Request for Variance under Sec. 14-440 - Exterior Egress

214 Park Ave.

BUILDING PERMIT REPORT

DATE: 3/26/98 ADDRESS: 214 Park Ave
REASON FOR PERMIT: Amendment
BUILDING OWNER: Portland West
CONTRACTOR: Same
PERMIT APPLICANT: Don Kehlert
USE GROUP _____ BOCA 1996 CONSTRUCTION TYPE _____

ELEVATION
214 PARK
AVE.

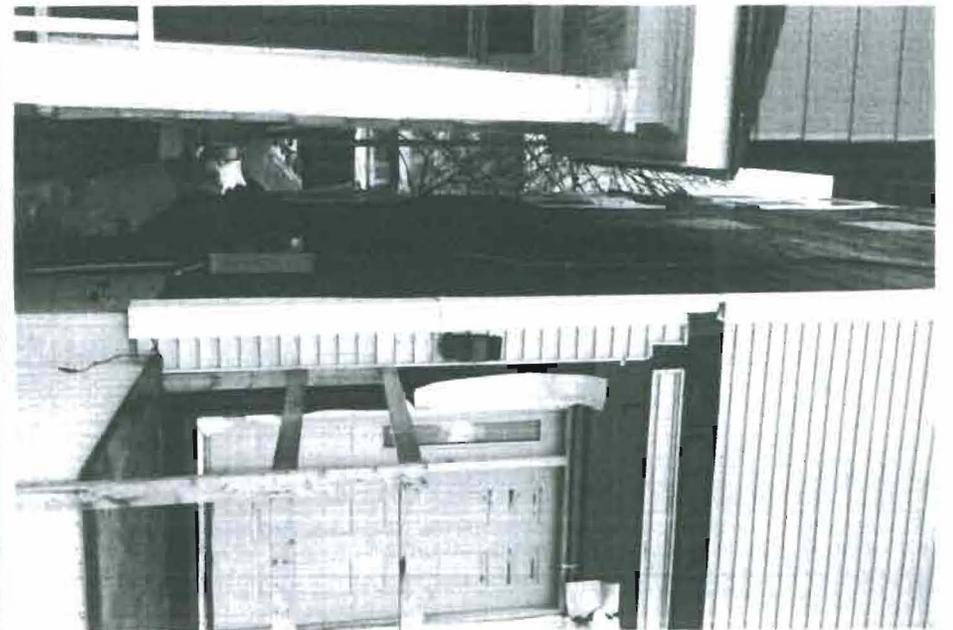
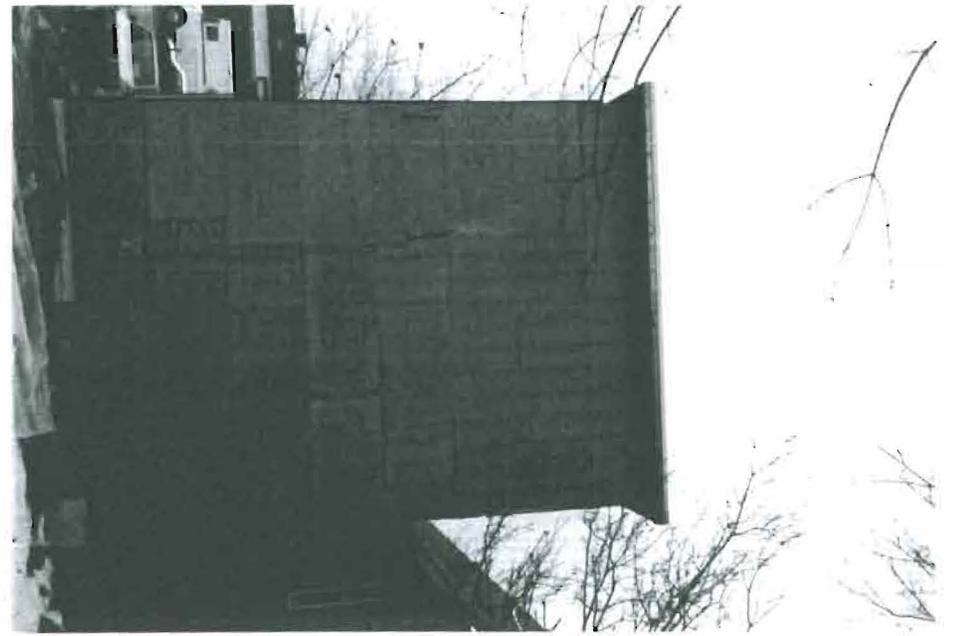
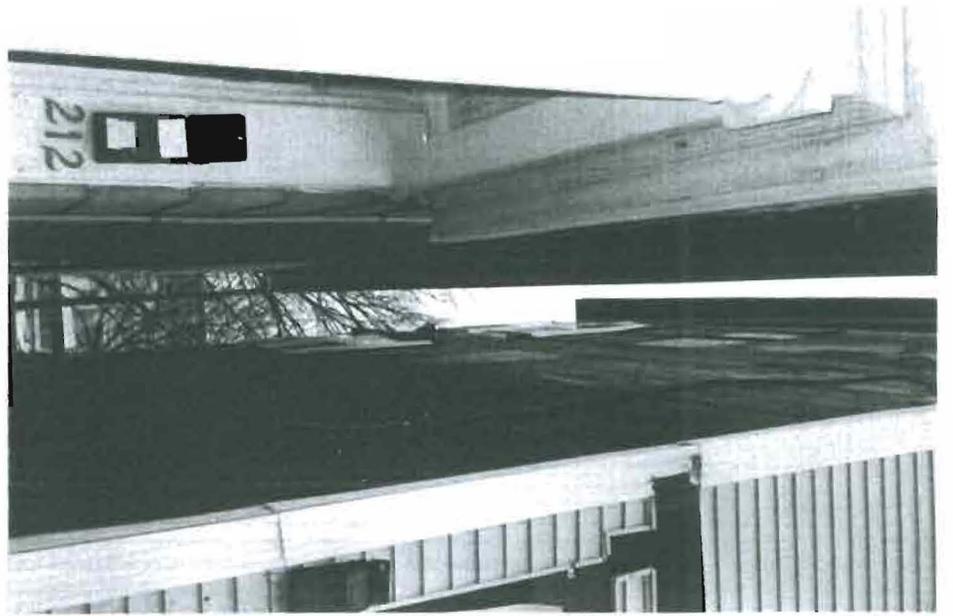
Approved with the following conditions: *1, *8, *29, *30, *31

29. All windows within 10' of fire escape must be protected.

30. Guards shall be 42" in height

X 31. Chapter 10 Section 1014.2 Treads, platforms and landings which are part of exterior stairways in climates subject to snow or ice shall be protected to prevent accumulation of same.
